From: Laura Gibbons <Laura.Gibbons@arun.gov.uk>
Sent: 22 June 2021 13:55
To: Planning.Responses <Planning.Responses@arun.gov.uk>
Cc: Simon Davis <Simon.Davis@arun.gov.uk>
Subject: RE: Planning Consultation on: AL/59/21/DOC

Condition 10- surface water drainage design

Application No: AL/59/21/DOC

Site Address: Springfield Hook Lane Aldingbourne PO20 3TE

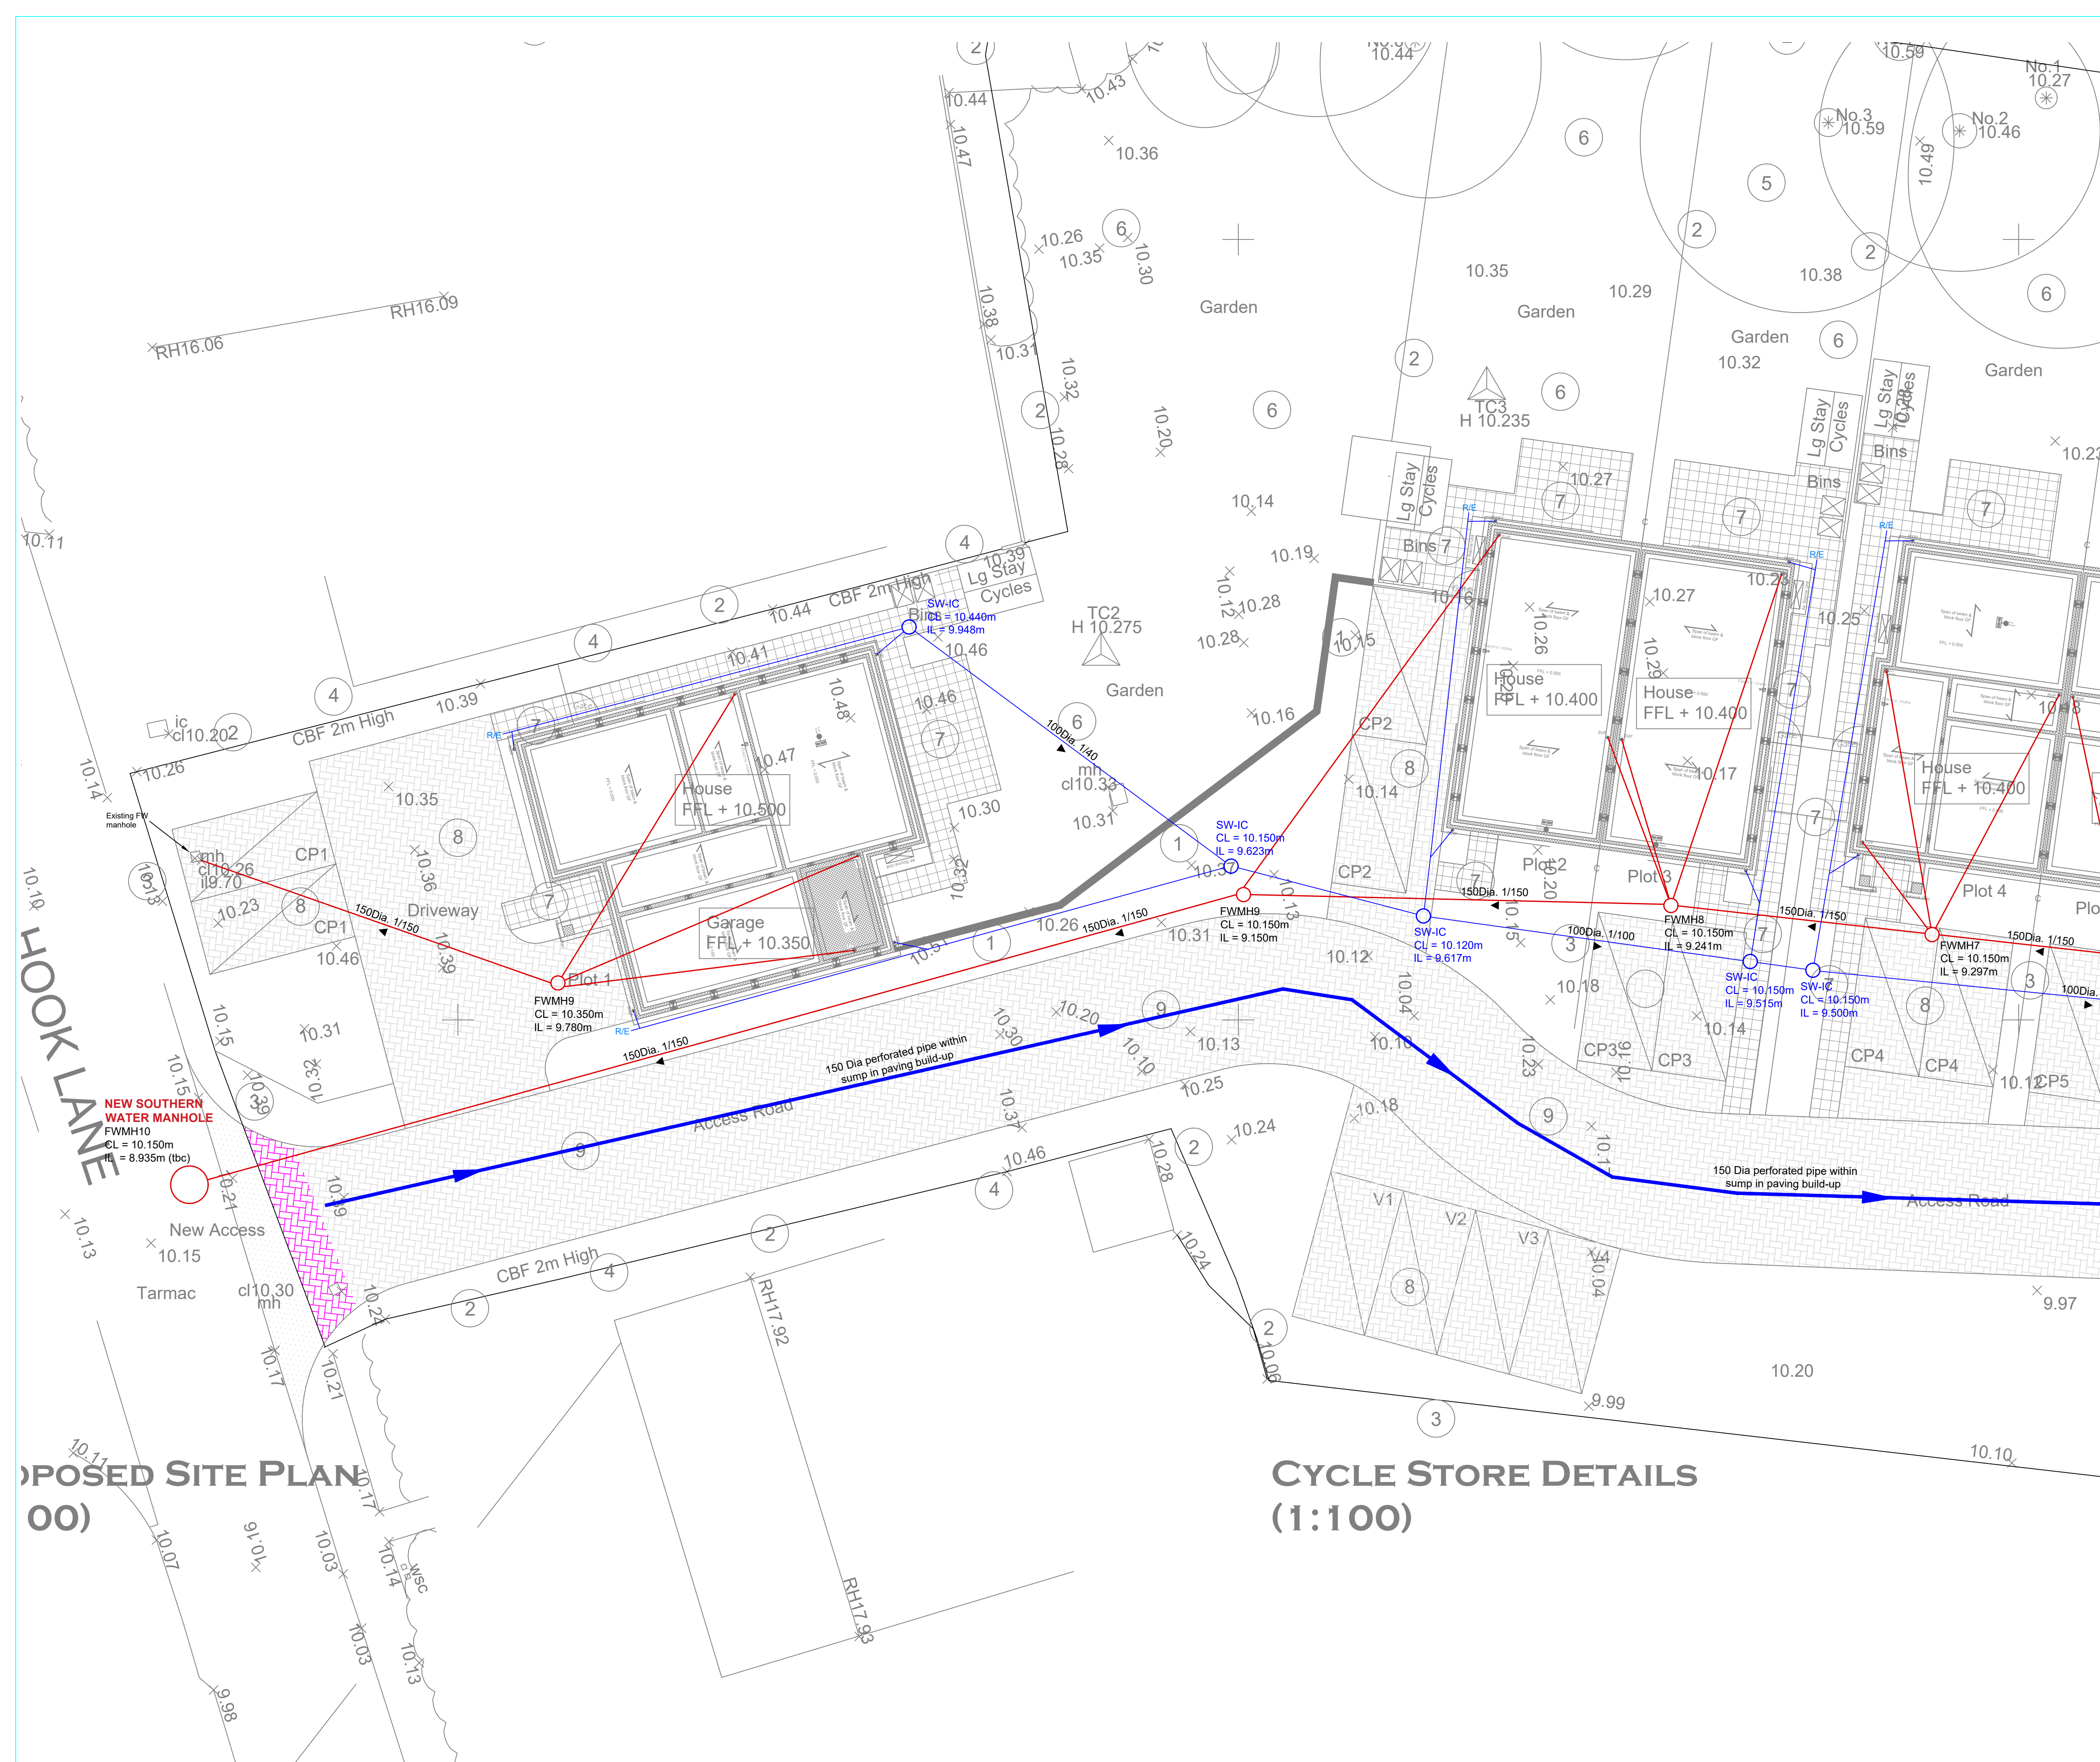
We note that it is proposed to pump surface water. This is not supported as per SuDS policy 3 of the adopted West Sussex Lead Local Flood Authority Policy on the management of surface water. The ditch system needs to be further investigated to determine the true invert level. A shallow gravity system must be fully explored.

Further information on the existing ditch must be provided. Evidence of land drainage consent must also be supplied with this application. This information has not been provided.
